WEST SUSSEX COUNTY COUNCIL CONSULTATION

TO:	Arun District Council FAO: Michael Eastham
FROM:	WSCC - Highway Authority
DATE:	26 October 2021
LOCATION:	Land At Angels Nursery Yapton Road Barnham PO22 0AY
SUBJECT:	BN/119/21/DOC Approval of details reserved by condition imposed under ref BN/84/20/PL relating to Condition Nos 14 - access & associated off-site highway works, 15 - internal roads & associated infrastructure, 18 - disused crossovers and/or accesses no longer required and 21 - Travel Plan. More info received.
DATE OF SITE VISIT:	n/a (desktop study undertaken)
RECOMMENDATION:	Advice
S106 CONTRIBUTION TOTAL:	n/a (see outline consent)

This is the second WSCC Highways (CHA) response to the planning application for approval of details reserved by condition imposed under ref BN/84/20/PL relating to Condition Nos 14 - access & associated off-site highway works, 15 - internal roads & associated infrastructure, 18 - disused crossovers and/or accesses no longer required and 21 - Travel Plan.

STATUS	DRAWING SUBMITAL
A1	
REVISION	RHS STATUS
C1	STAGE 5 - CONSTRUCTION
DRAWING No.	
19812-GS-Z1-XX-DR-C-1014

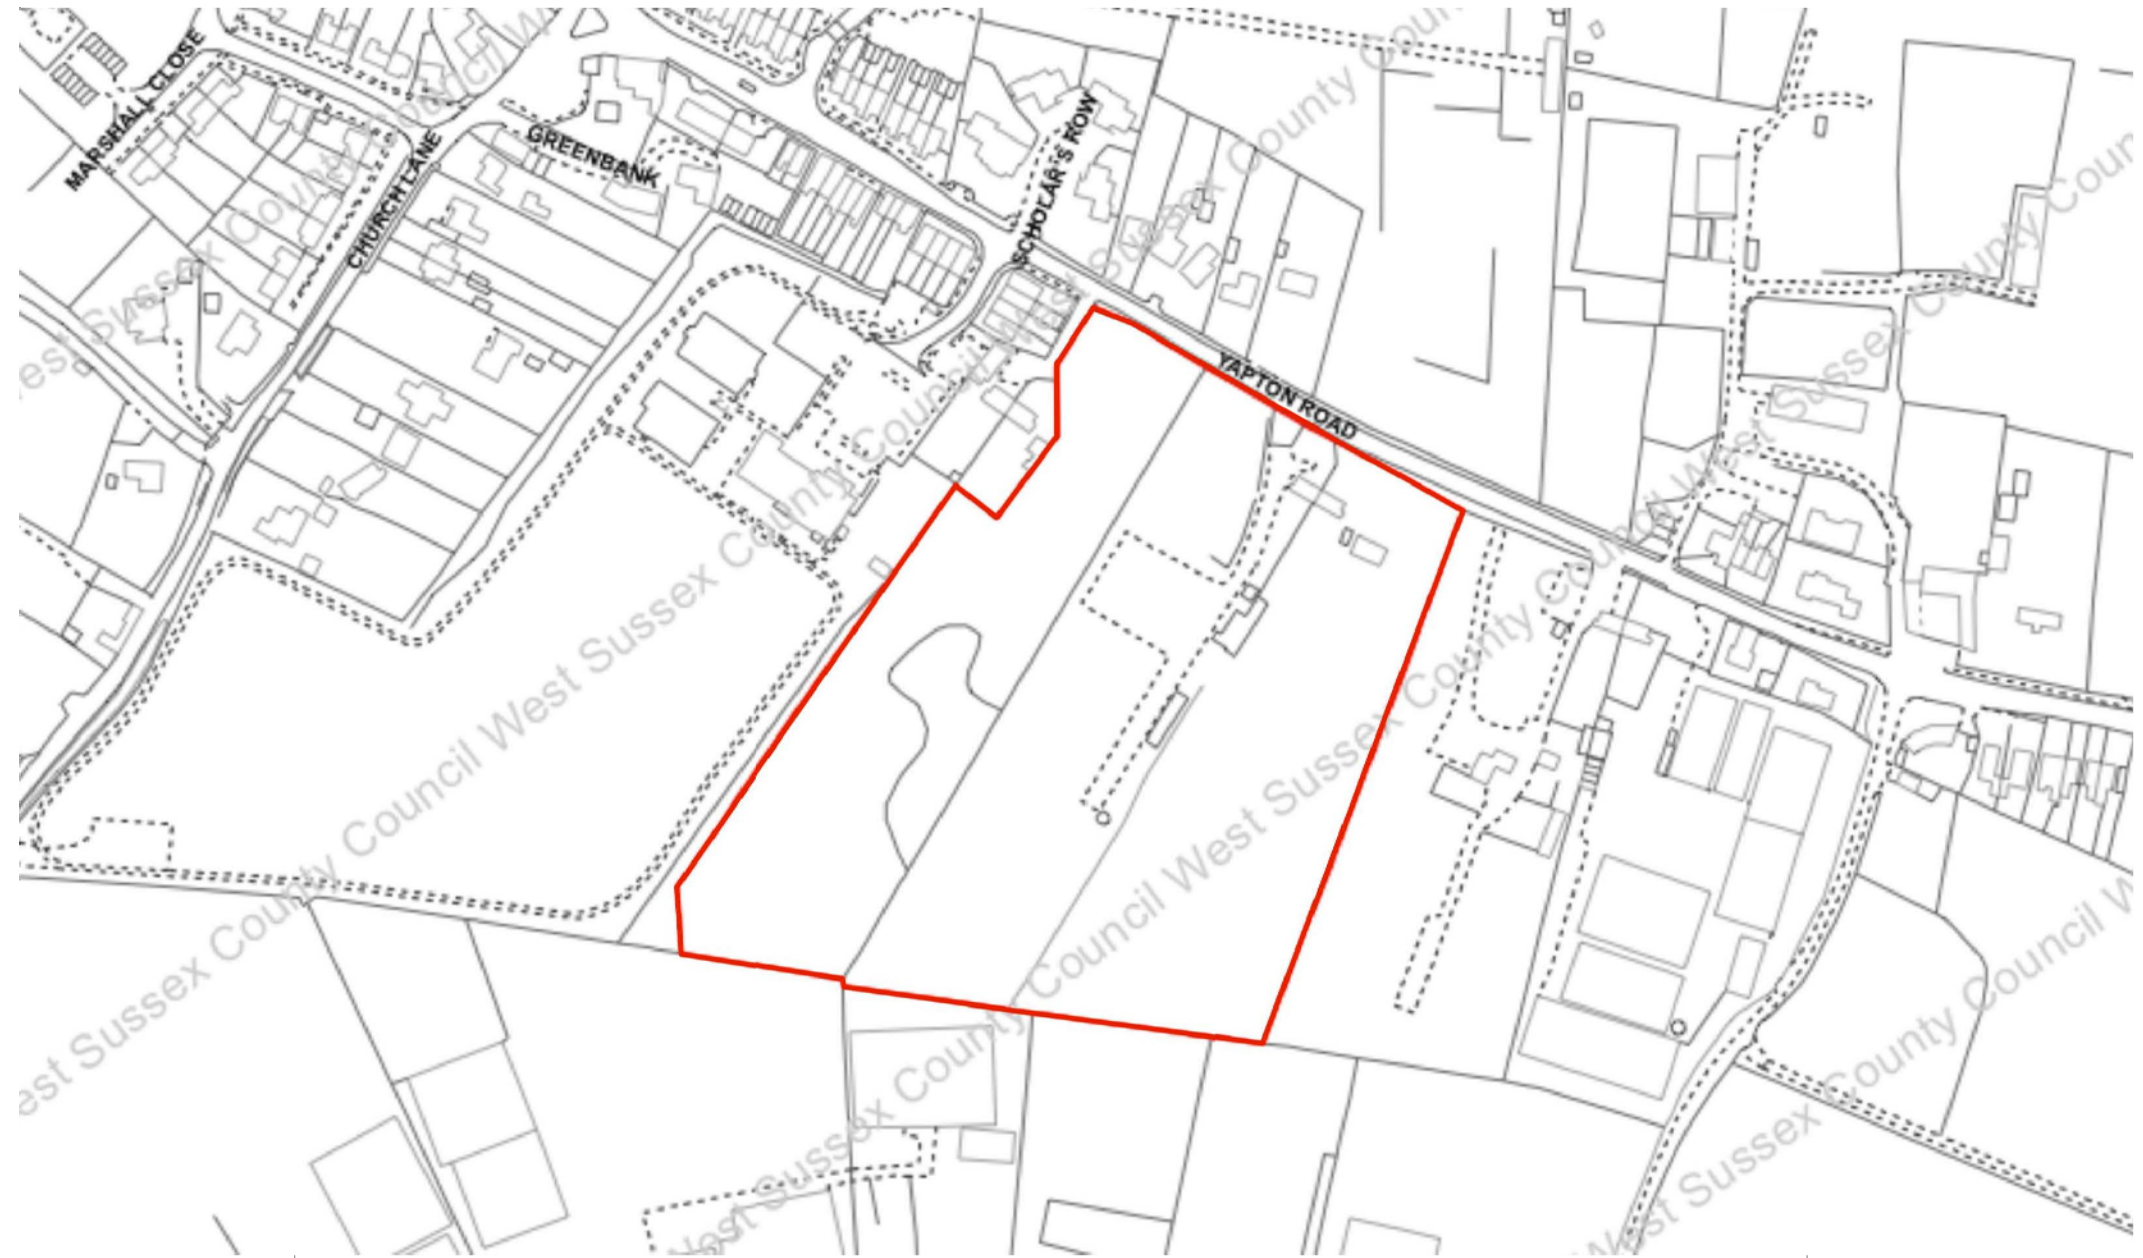
1. Condition 14 (access and associated highways works) – Drawing 19812-Z1-XX-DR-C-1014 Rev. 'C' has been provided. However, at the time of writing the latest drawing that WSCC is aware of being used for S38/278 purposes is Rev. 'C1'. This (or any subsequent approved drawing) should be referenced in any planning permission granted for this DOC application. *This is now shown.*
2. Condition 15 (internal roads and associated infrastructure) – 'External Works' drawings sheets 1 and 2 – No.'s 19812-GS-Z1-ZZ-DR-C-2080 and 19812-GS-Z1-XX-DR-C-2081 show the internal road layout and associated surfacing materials for roads, private drives, footways and footpaths etc. With regard to the layout, some minor changes are required. They are as follows:
 - Tie-in of cycle route to-and-from access road and shared-use path opposite Plot 6 to be better-defined. Location as follows (PTO):
